Your Reference SSD-14378717

City of Parramatta Council submission to Response to Further Information (September 2023) for the Telopea Concept Plan and Stage 1A State Significant Development Application

ATTACHMENT A

1. Stage 1A – Built Form and Design Waiver

DRAWING TITLE
STAGE 1 - BLDG. B EAST
& WEST ELEVATIONS

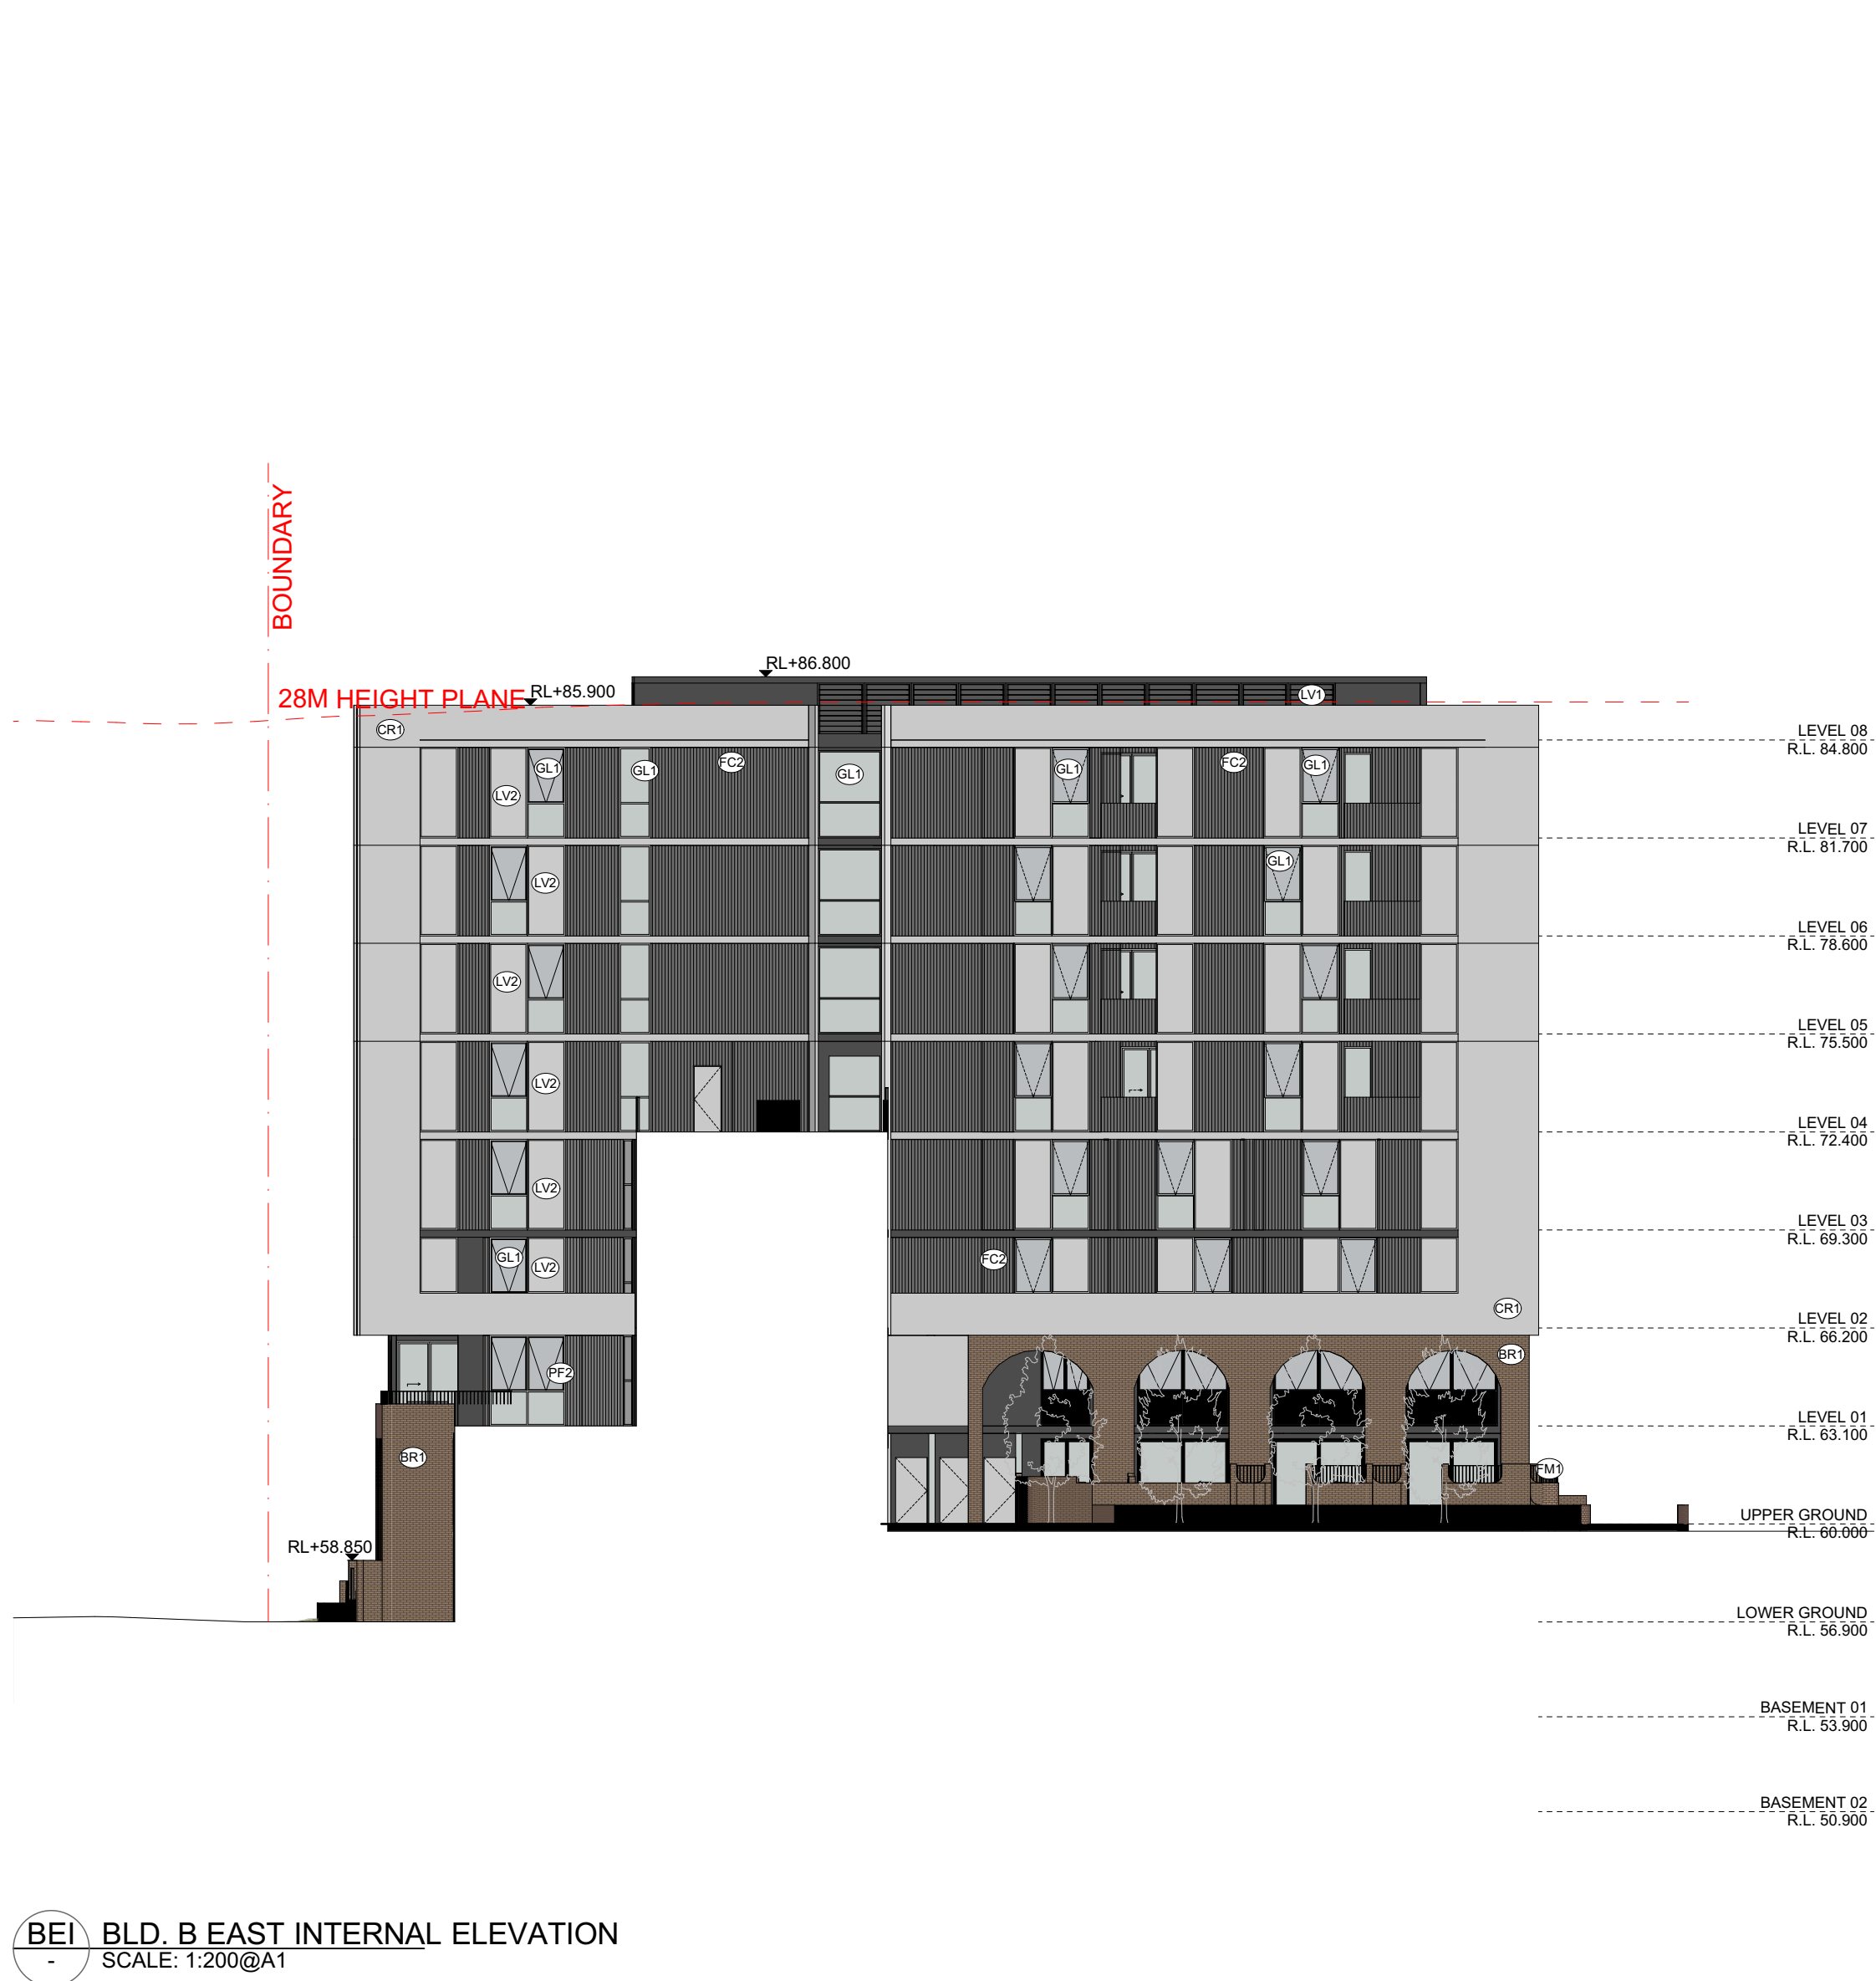
- f) **Building B** - Council does not support the Clause 4.6 variation (as amended) to create additional height on Building B from 14 and 9 storeys to 15 and 10 storeys. Council does not consider adequate justification has been provided to support the extent of additional

variation being sought. Furthermore, Building B should be reduced in length or introduce building breaks and greater articulation.

STAGE 1A - PLAN 1

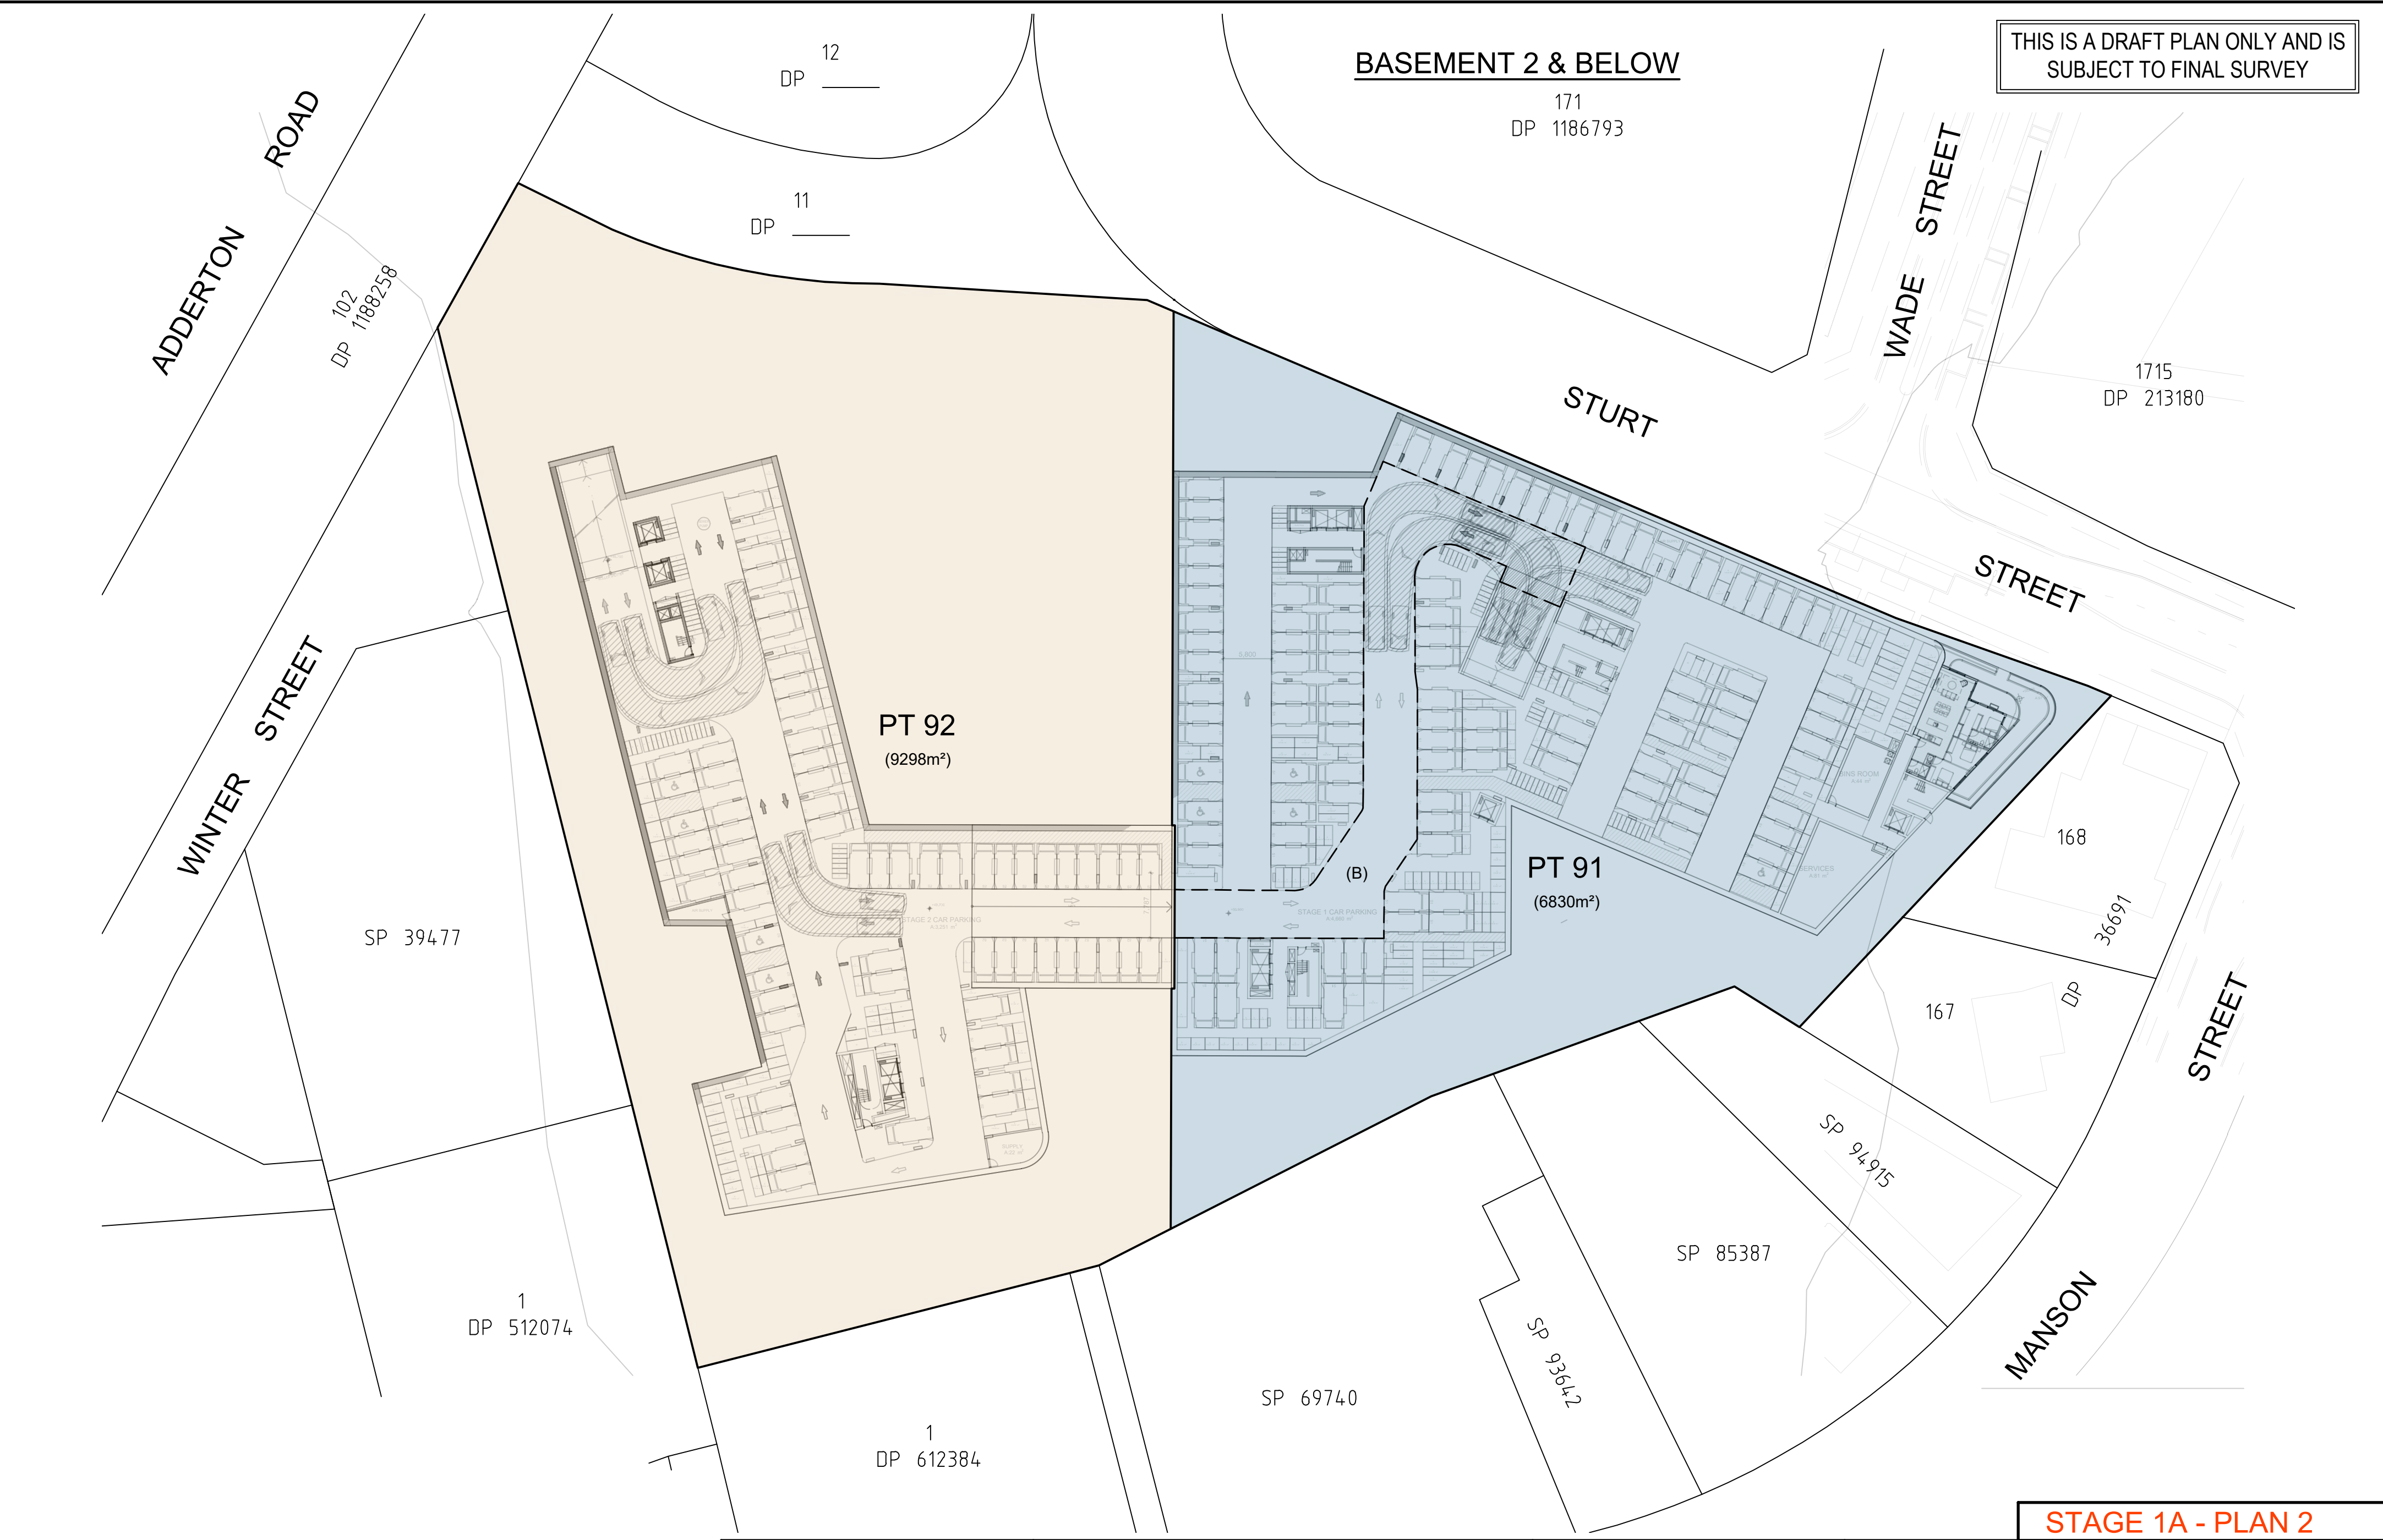
- b) **Confirmation of the subdivision and size of the Neighbourhood Park.** The area of the Neighbourhood Park differs between the VPA Letter of Offer and the Subdivision Plan. Furthermore, the Subdivision Plans should be updated to show the Neighbourhood Park dedicated as a separate lot.

BASEMENT 02
SCALE: 1:500@A1

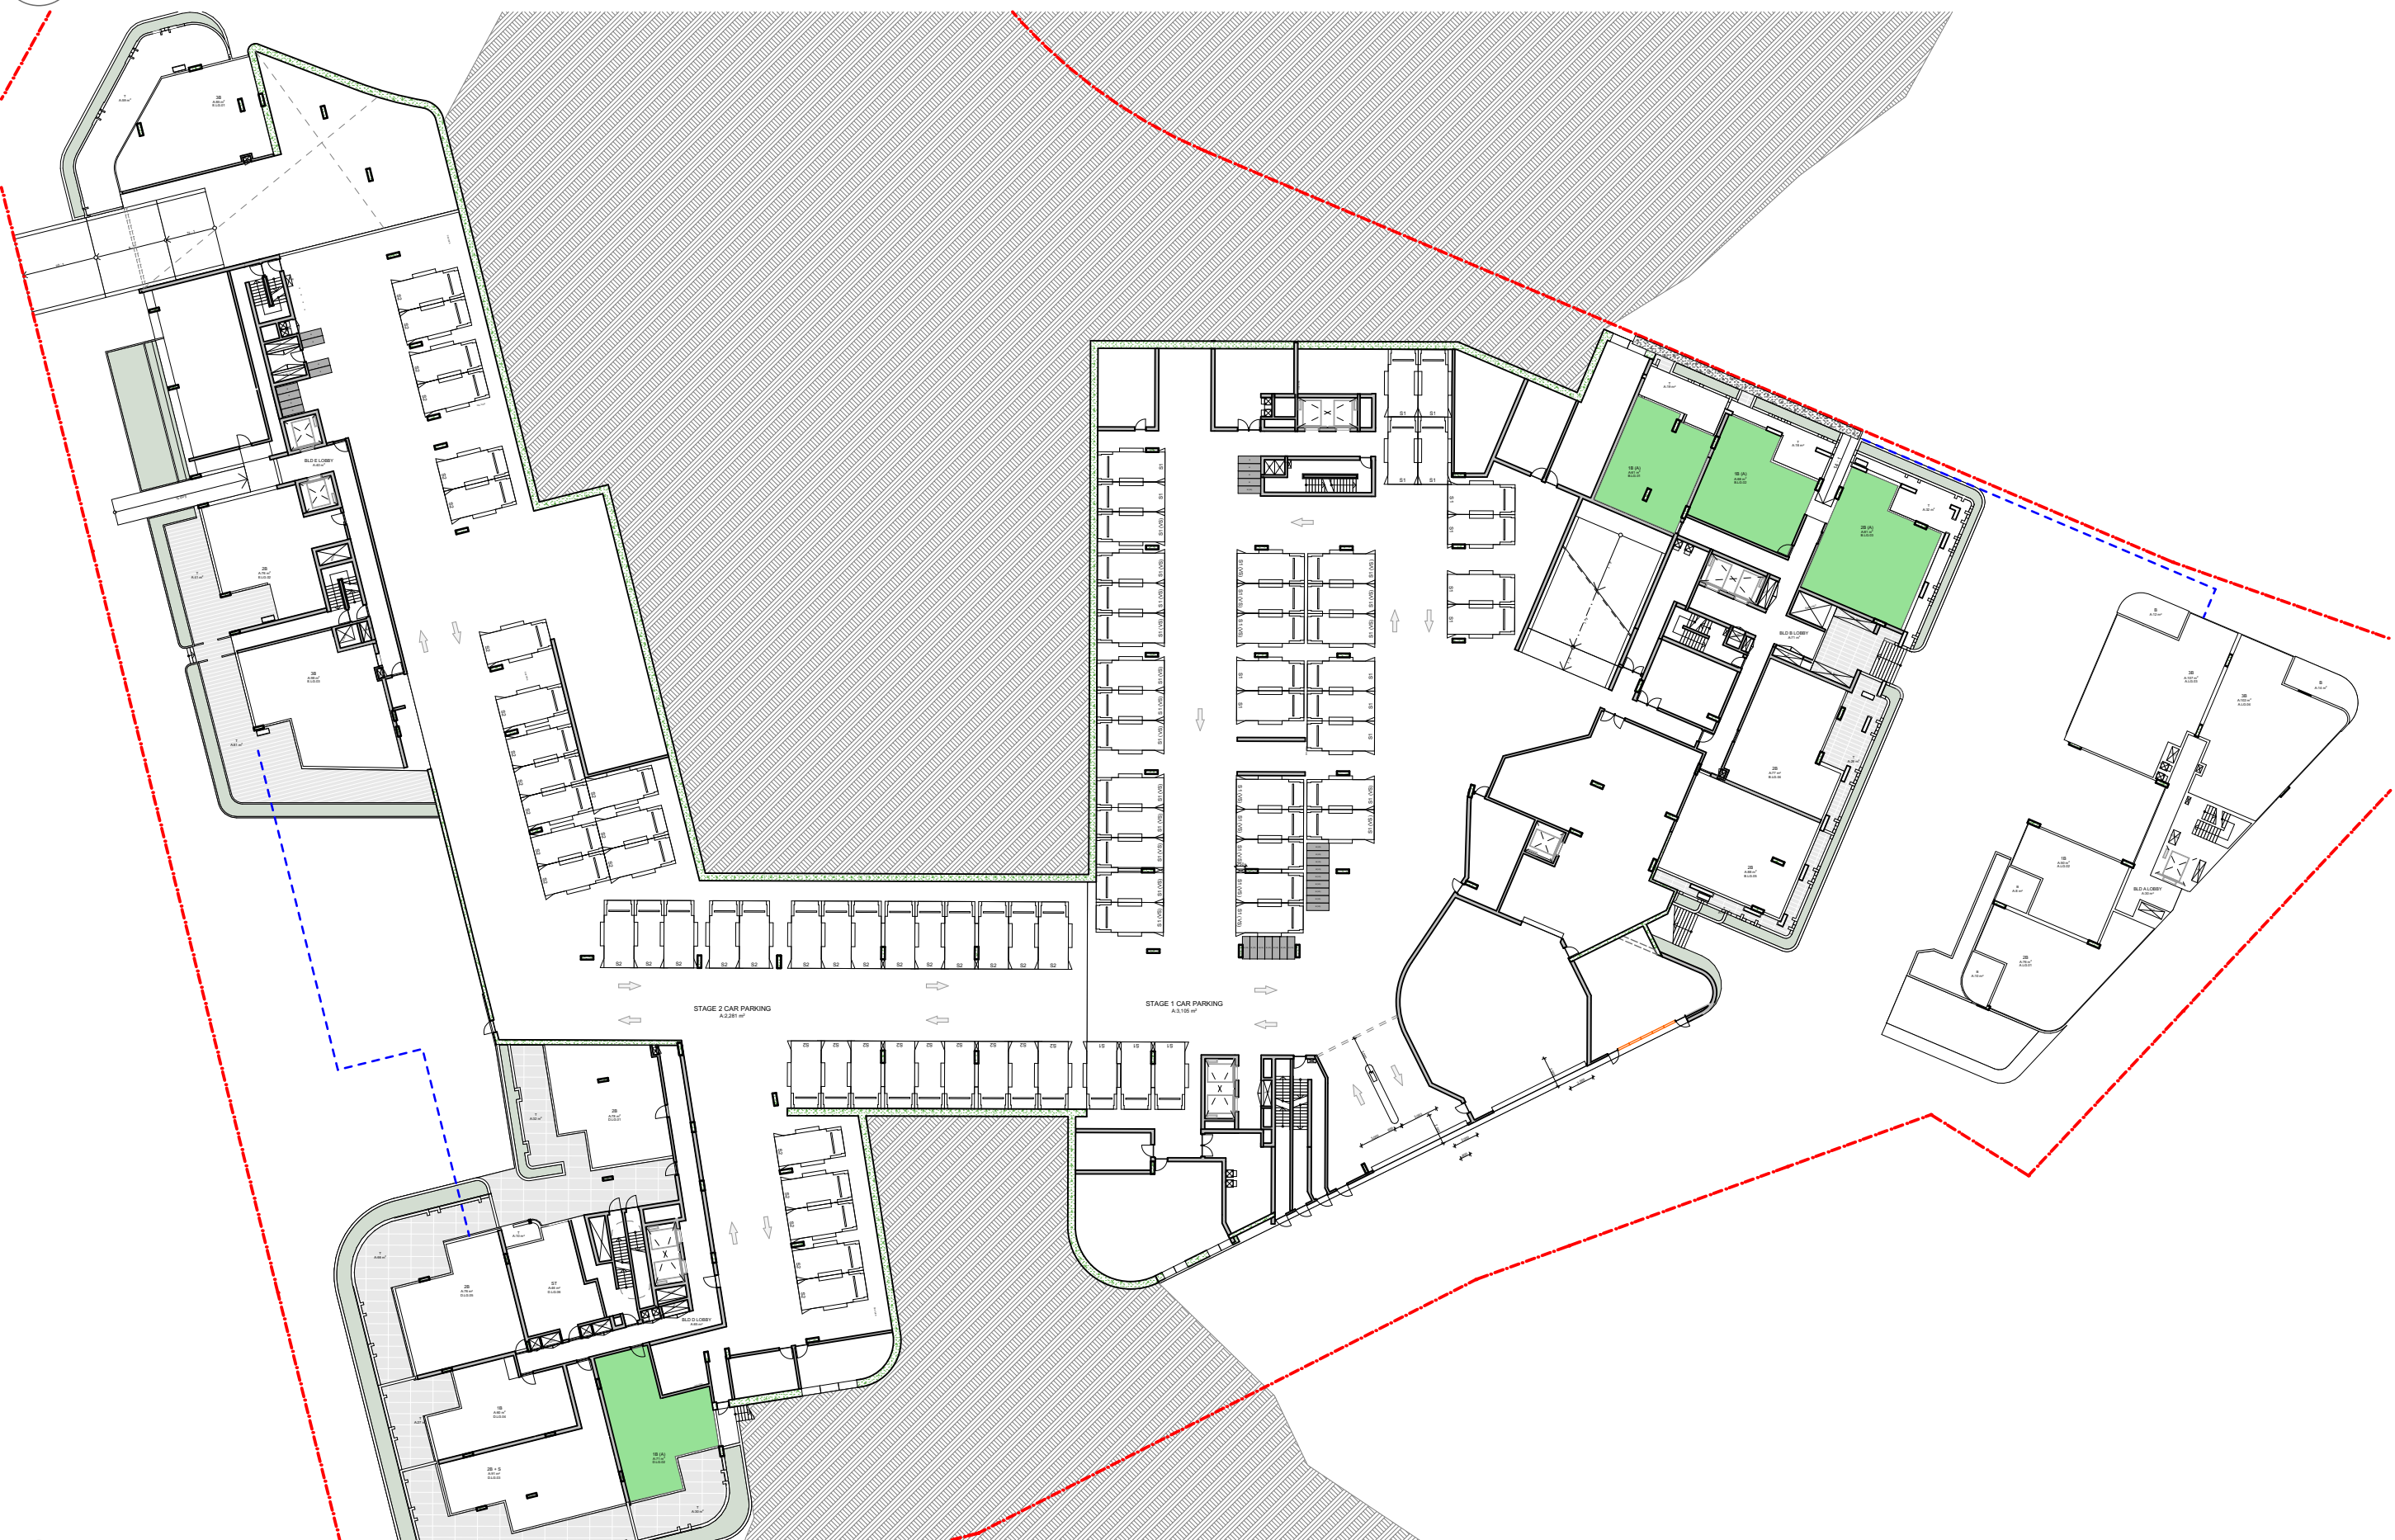
- a) **The Neighbourhood Park should be free of all basement structures.** A review of the Subdivision Plan, Landscape Plan and Basement Plan indicates a basement encroachment of the western side of the Neighbourhood Park (refer red hatched line at Figure below). Although the encroachment is excluded in the subdivision plan, this will complicate future liability and maintenance responsibility for Council.
